KITTITAS COUNTY

MEMORANDUM

TO: All Staff
FROM: Public Works Plan Review Team
DATE: July 8, 2026- SURVEY JULY 20, 2026
SUBJECT: BL-26-00009 Helveston

RECORD OF SURVEY
PART OF BLOCK G, SUNLIGHT WATERS II
& OF THE SOUTHEAST QUARTER OF SECTION 24,
TOWNSHIP 19 NORTH, RANGE 16 EAST, W.M.

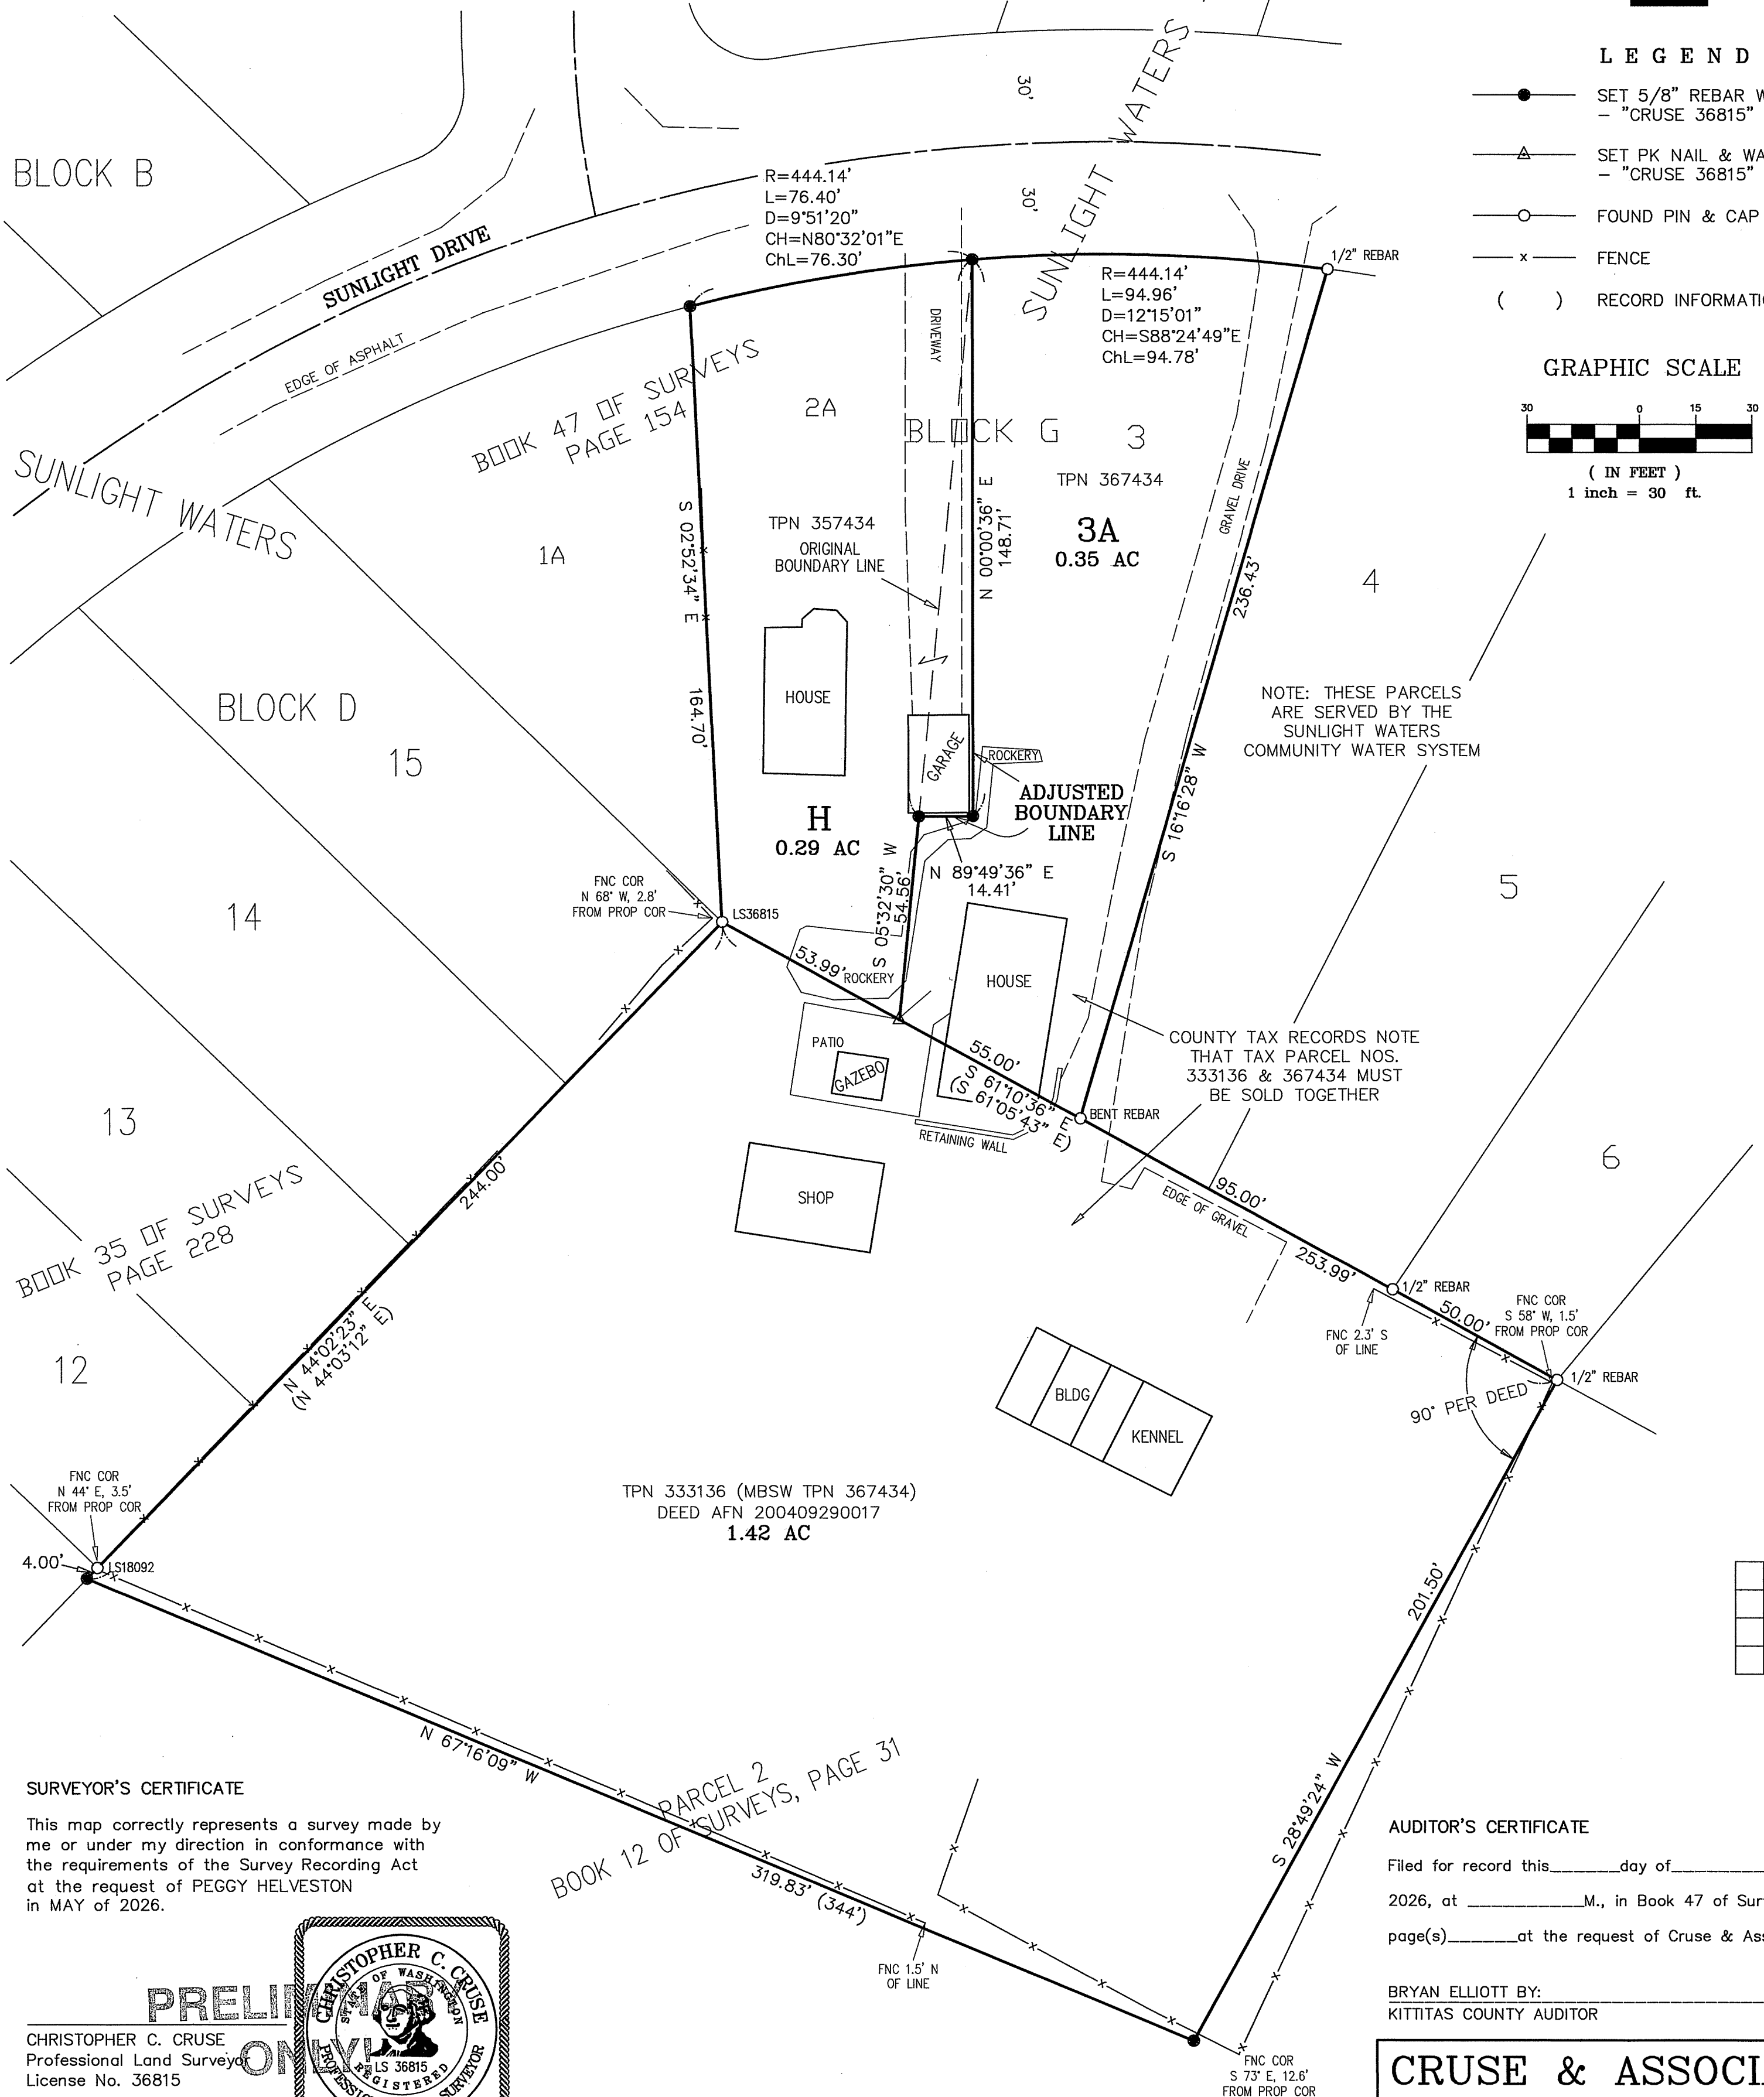
SURVEY	As the application does not contain a survey map, comments are herein reserved until final submittal. (KH) UPDATE 07/21/2026 1. Please identify offset distance between adjusted boundary and existing face of garage. 2. If the garage eaves present an aerial trespass, please note on the face of the survey. 3. Please identify Sunlight Drive as being a country right of way. OF NOTE (not a requirement for approval) 4. The building outline for the house on Lot H does not appear to match aerial images from 2022, particularly along the south extents. The planner of record has deemed that correcting this is not a requirement. 5. There appears to be a structure located North of the House on Lot H per

aerial images, which may actually encroach onto the 10' setback. The planner of record has deemed that correcting this is not a requirement. (JT)
TRANSPORTATION CONCURRENCY	No Comment. (RC)
FLOOD	No comments. (SC)
WATER MITIGATION/ METERING	No comments. (SC)
AIRPORT	Project is not located withing Airport Overlay. (RC)
